***Adaptive Reuse of the Clare Hotel and
Administration Building on Block 3A***

***Central Park, Chippendale
(Former Carlton United Brewery)***

MP 11_0089 - Modification 1

Director-General's
Environmental Assessment Report
Section 75W of the
Environmental Planning and Assessment Act 1979

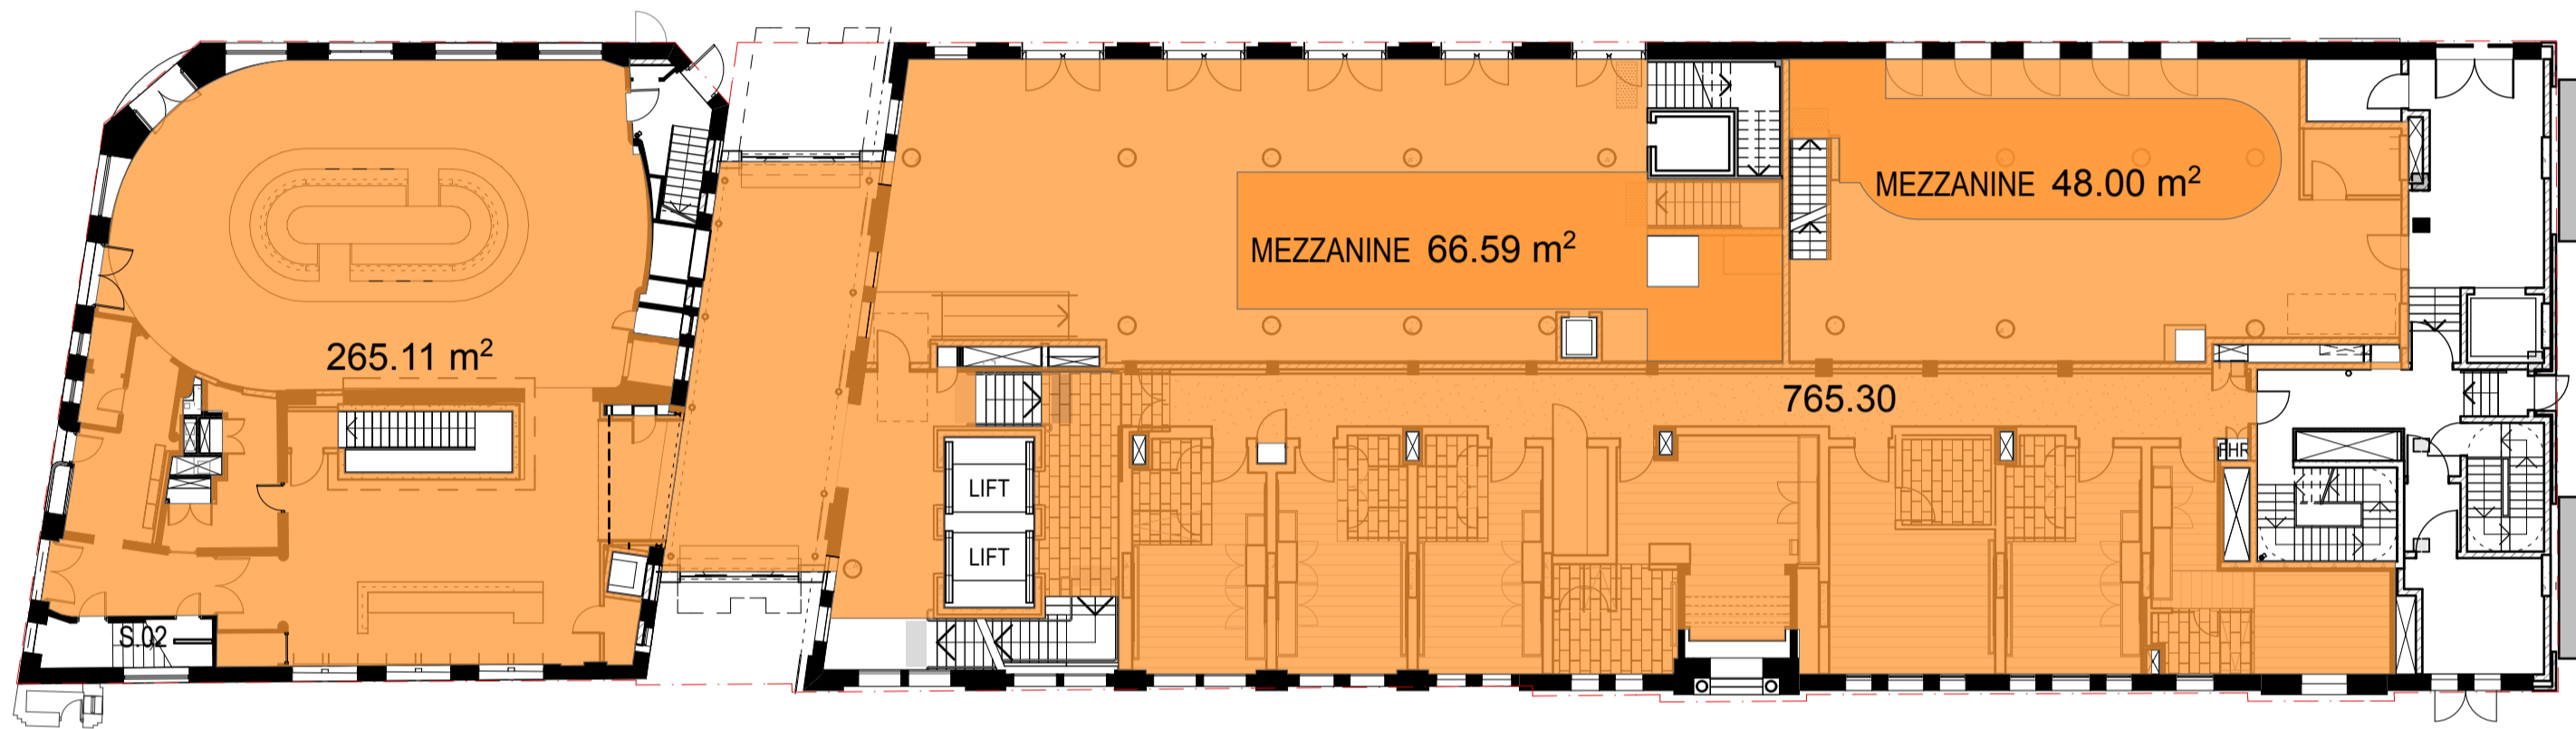
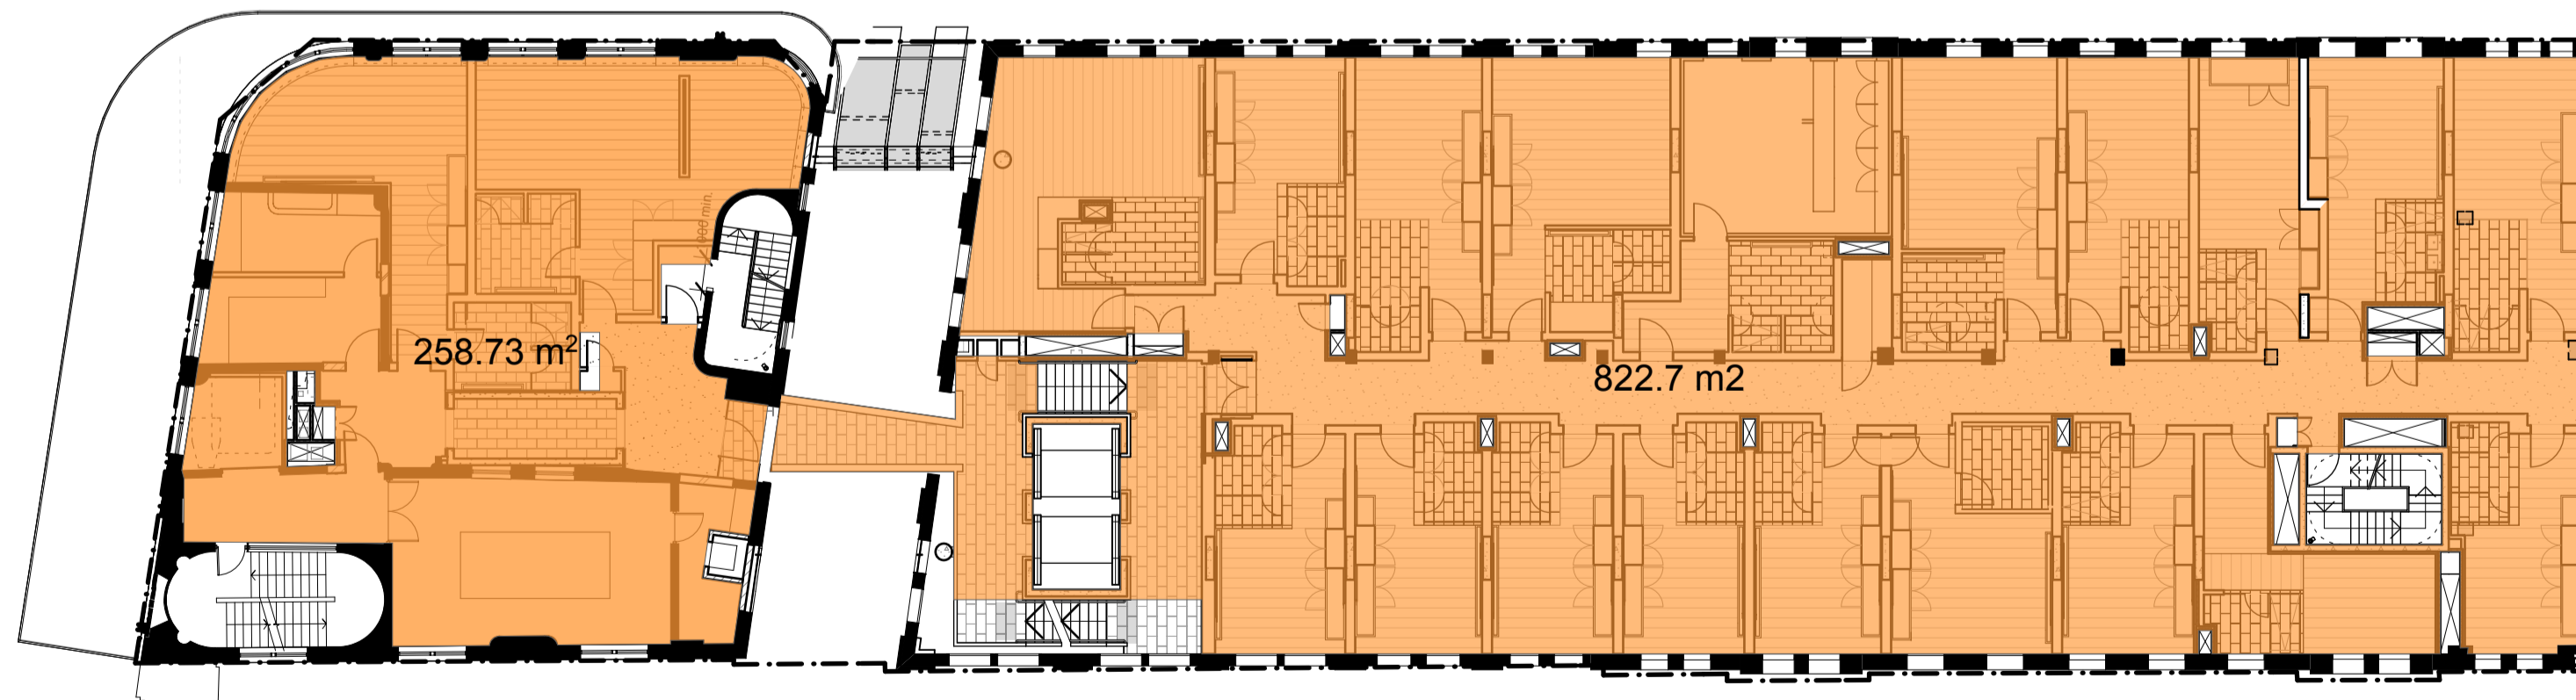
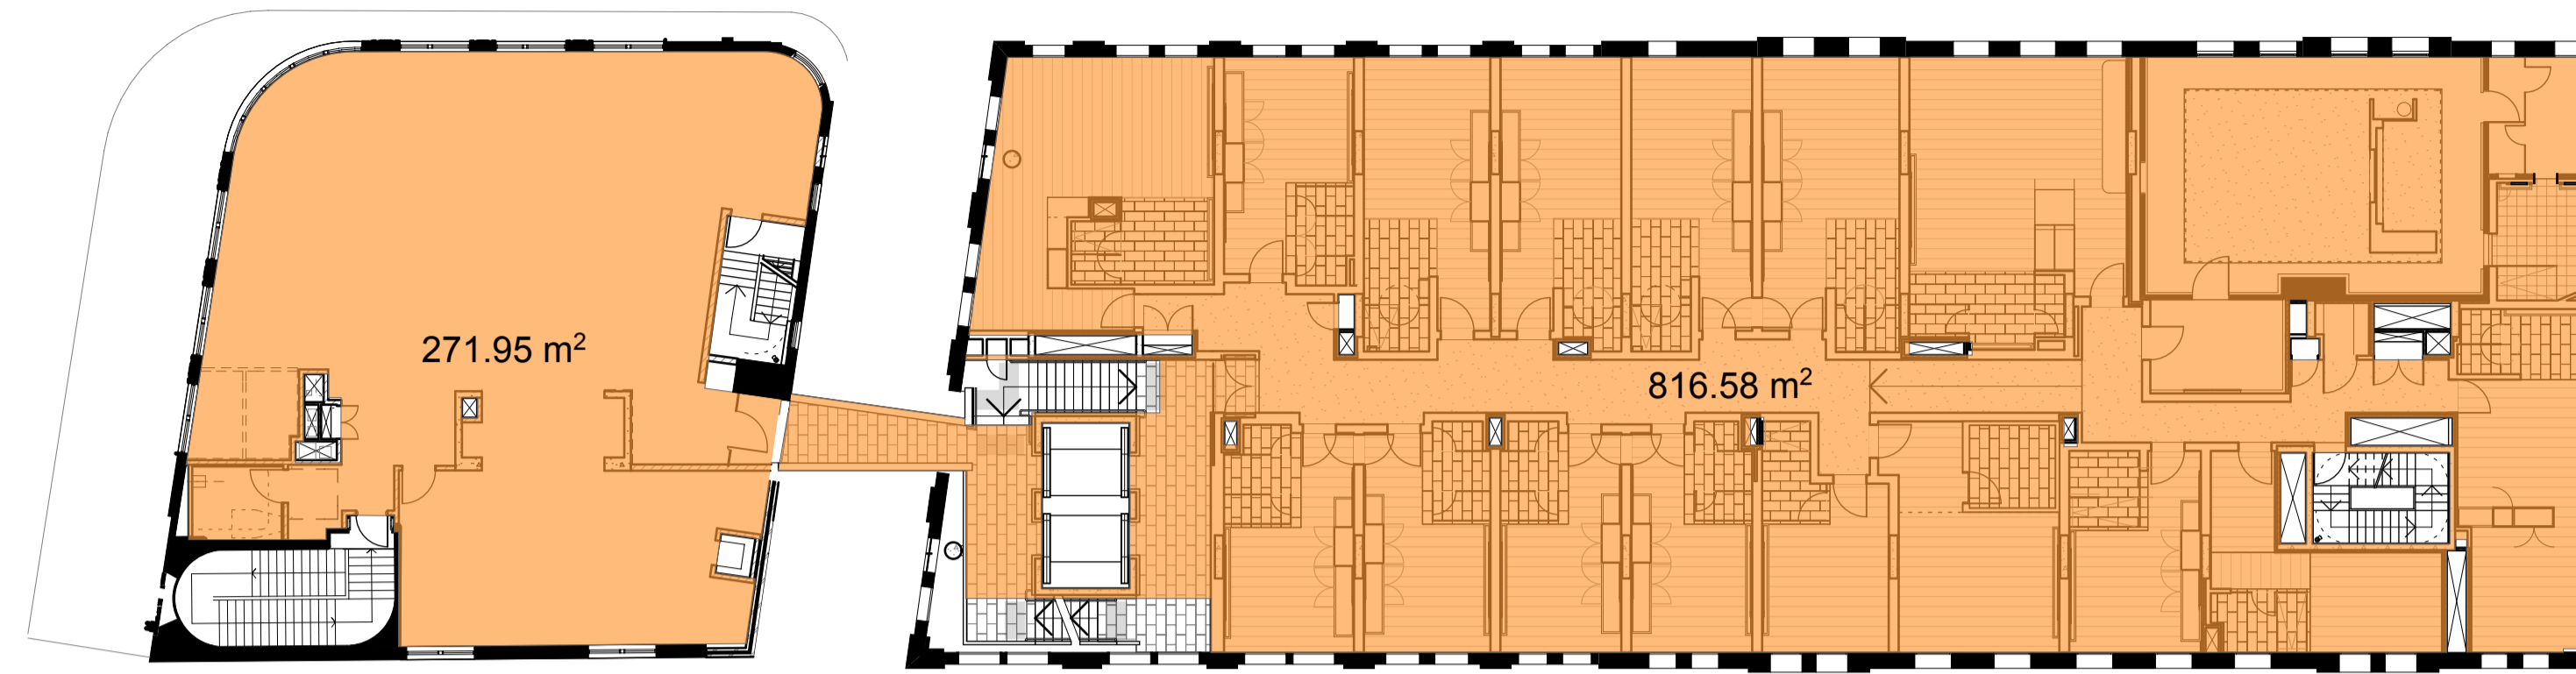
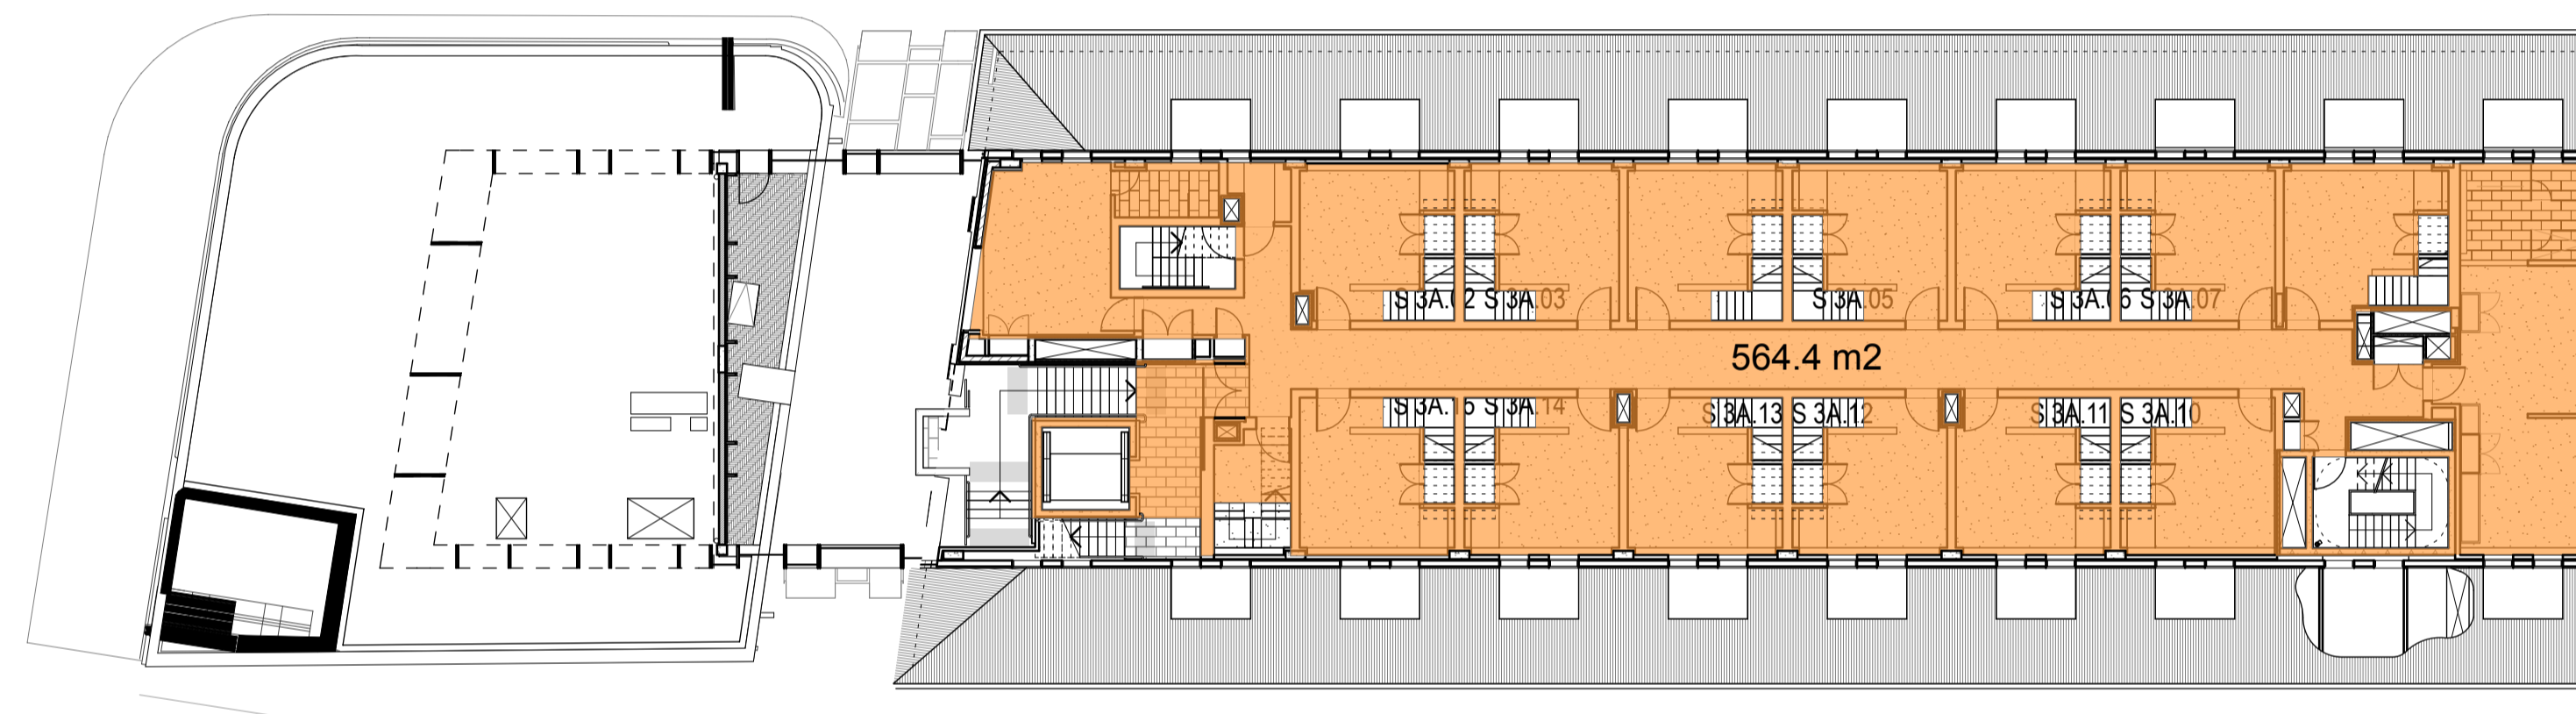
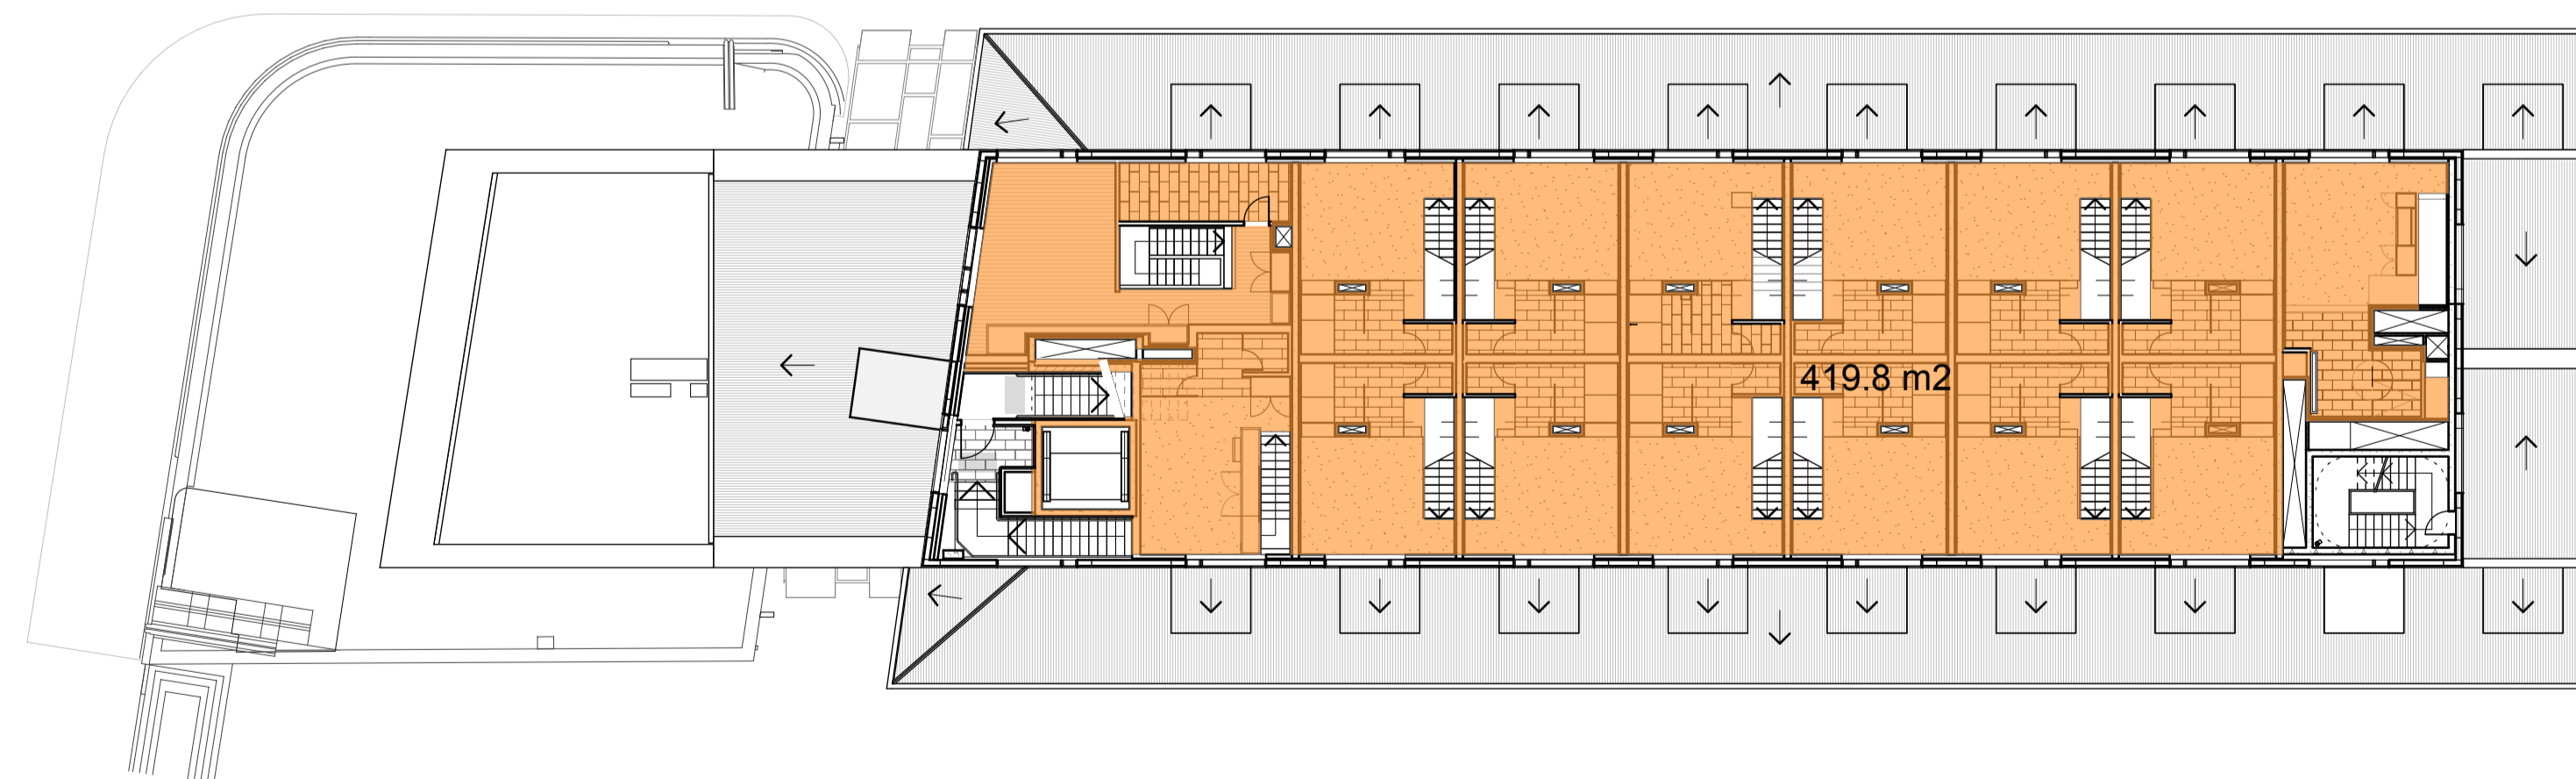
The proposal seeks to increase the GFA of food and drink premises from 1,098m² to 1142.8m² (an additional 44.8m²) without amending the total approved GFA (4,595.9m²). The increase in the food and drink GFA of 44.8m² has arisen as a result of internal design amendments to each level throughout the Clare Hotel and Administration building. **Table 1** shows the change in GFA allocated on each level of both buildings.
